## WESTMEAD CATHOLIC COMMUNITY – SSSA RESPONSE TO SUBMISSIONS CITY OF PARRAMATTA COUNCIL MEETING MINUTES Held via Videoconference on 24 July 2020 at 11:00AM

- 3.2. **CoPC Query No.2 & 3:  
Existing queuing lengths in right turn bay & increase in PM peak in 2033 (as per Table 2)  
using existing main driveway shows an increase in volumes.**

**Council staff to review pick up/set down arrangements. While 233 students in 15 minutes is achievable on the site, it's appears to not be achievable under the current and proposed layout**

Figure 12 Revised pick-up and drop-off layout

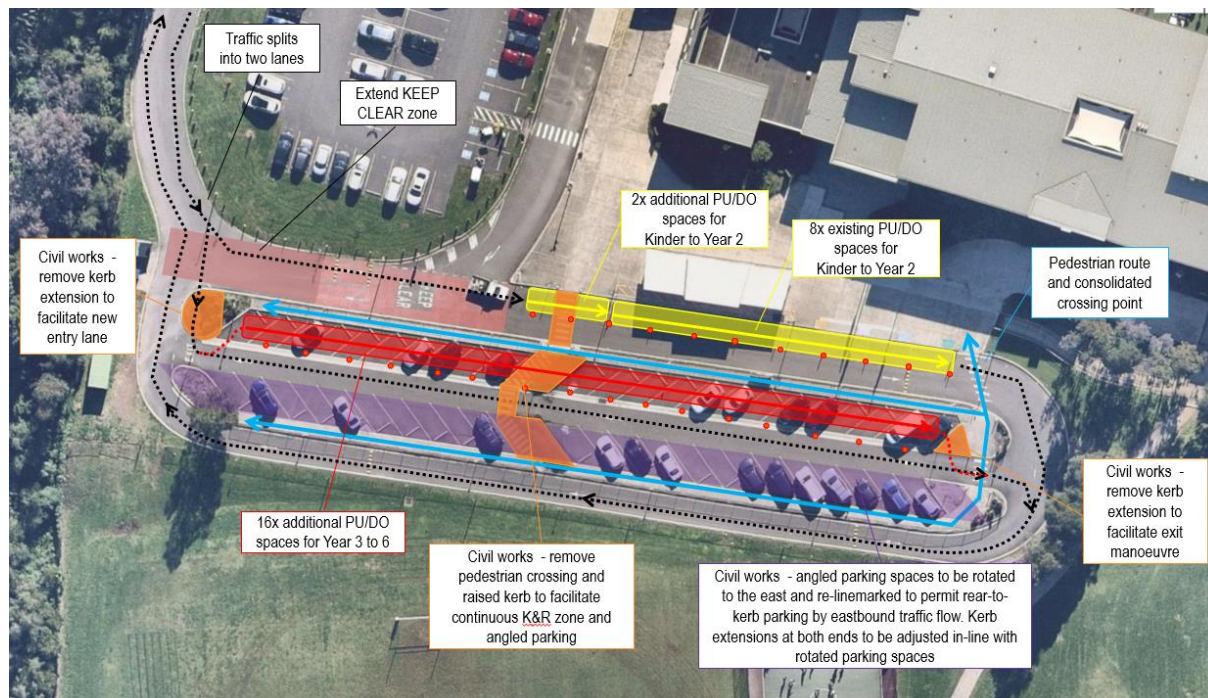
3.4.1. RS (CoPC) suggested that Council could provide traffic advice on how the existing pickup / drop off system is operating and possibly identify resolutions to internal queuing issues. All to review at next weeks meeting, noting CEDP are more than happy to take Councils advice onboard and implement solutions as soon as practicable. Note

- 4.1. CoPC, CEDP, TTPP and WINIM conducted a site meeting on 28 July 2020 to observe the operation of the existing drop off system and the existing queuing issues raised as a concern above. Observations commenced at 7:45AM and finished around 8:45AM.

- RS (CoPC) acknowledged that the AM queuing issues are predominantly due to the internal operation of the site and particularly the efficiency of the drop off system for the morning set down.

- SB (TTPP) noted that the TAIA assumes an average AM and PM set down of 2 minutes per vehicle movement i.e. a 2 minute allowance for students to exit cars. RS (CoPC) agreed that this is conservative and suggested that the existing pickup / drop off area could become more efficient with immediate and temporary measures.
